**CITY OF PORTLAND**  
**DEPARTMENT OF PLANNING & URBAN DEVELOPMENT**  
 389 Congress Street  
 Portland, Maine 04101

**Inspection Violations**

<b>Owner/Manager</b> ASHMORE RALPH W		<b>Inspector</b> Chris Hanson	<b>Inspection Date</b> 2/9/2007
<b>Location</b> 68 WINDING WAY	<b>CBL</b> 085 T001001	<b>Status</b> Re-Inspect 30 Days	<b>Inspection Type</b> Complaint-Inspection

A  
Existing First Floor  
Yurt Plan  
1/4" = 1'-0"

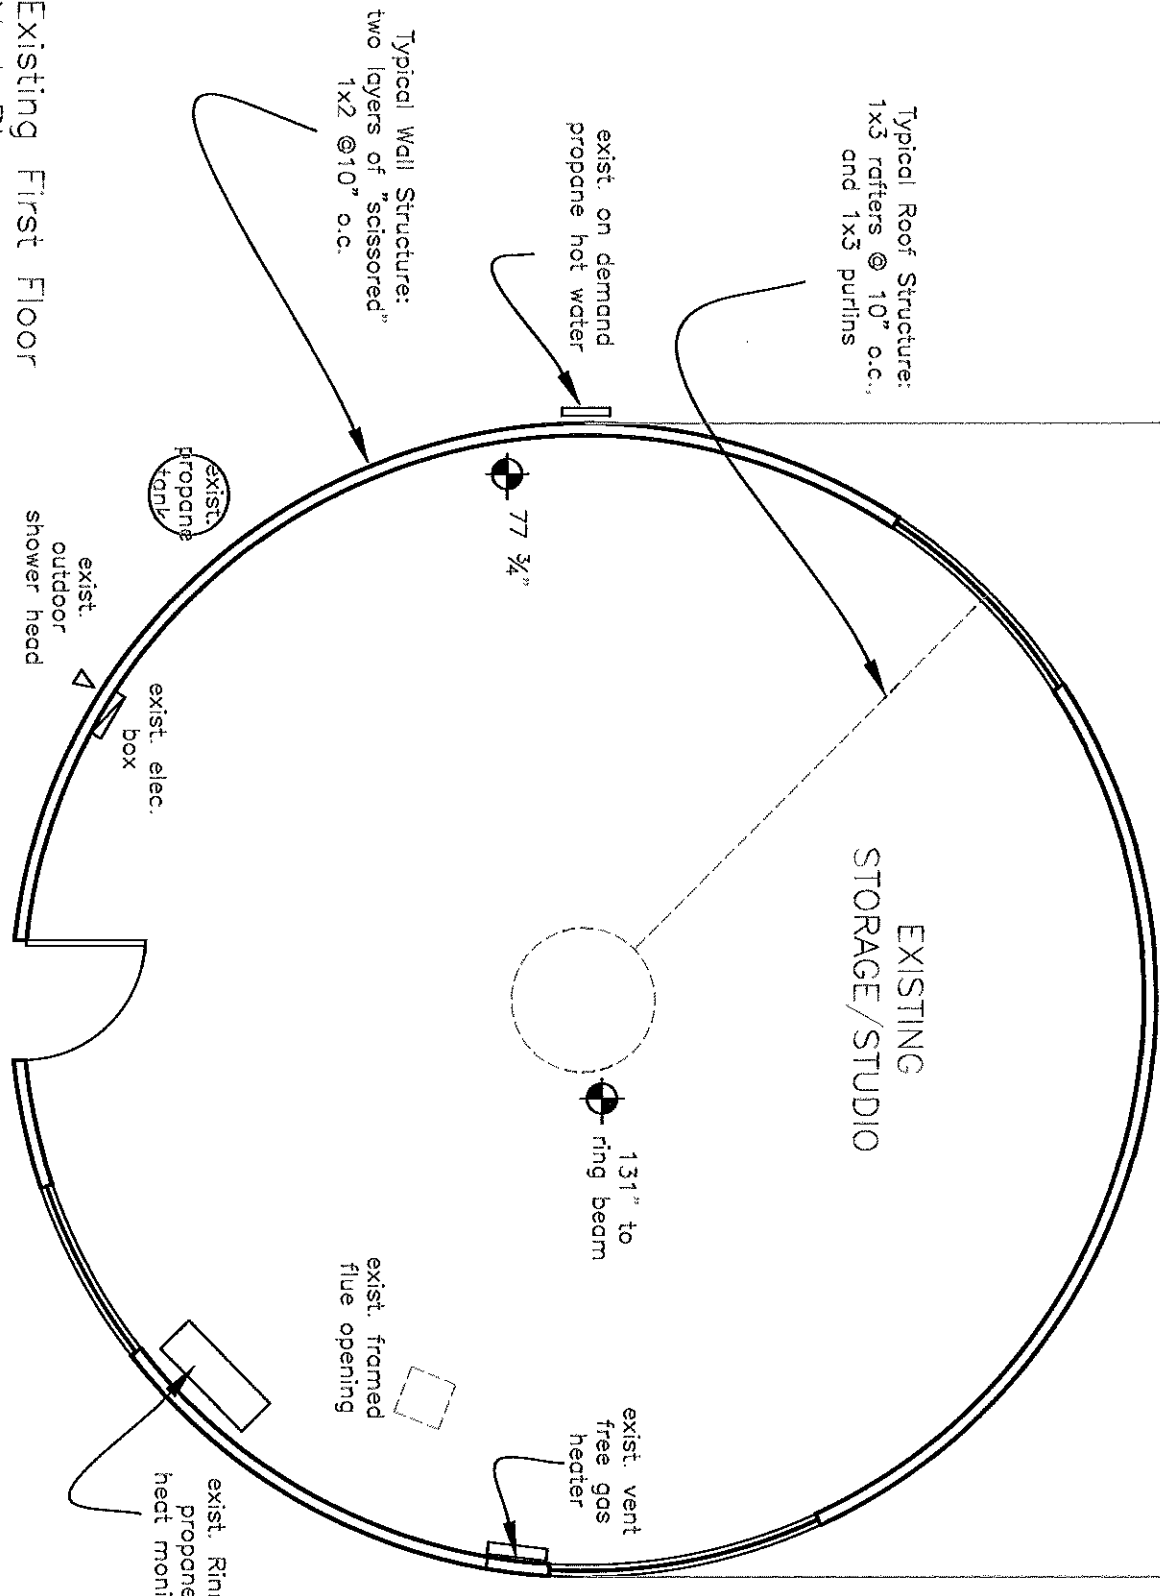
<b>Code</b>	<b>Int/Ext</b>	<b>Floor</b>	<b>Unit No.</b>	<b>Area</b>	<b>Compliance Date</b>
1) 6-110.6	Interior				06/18/2009
<b>Violation:</b>					
<b>Notes:</b> Basement apartment not permitted . All Kitchen facilities mut be removed.					
2) 105.1	Interior			Yurt	06/18/2009
<b>Violation:</b> Building w/o Permit					
<b>Notes:</b> Buildiong / Yurt permitted as storage only. Plumbing for bath facilities and kitchen not permitted
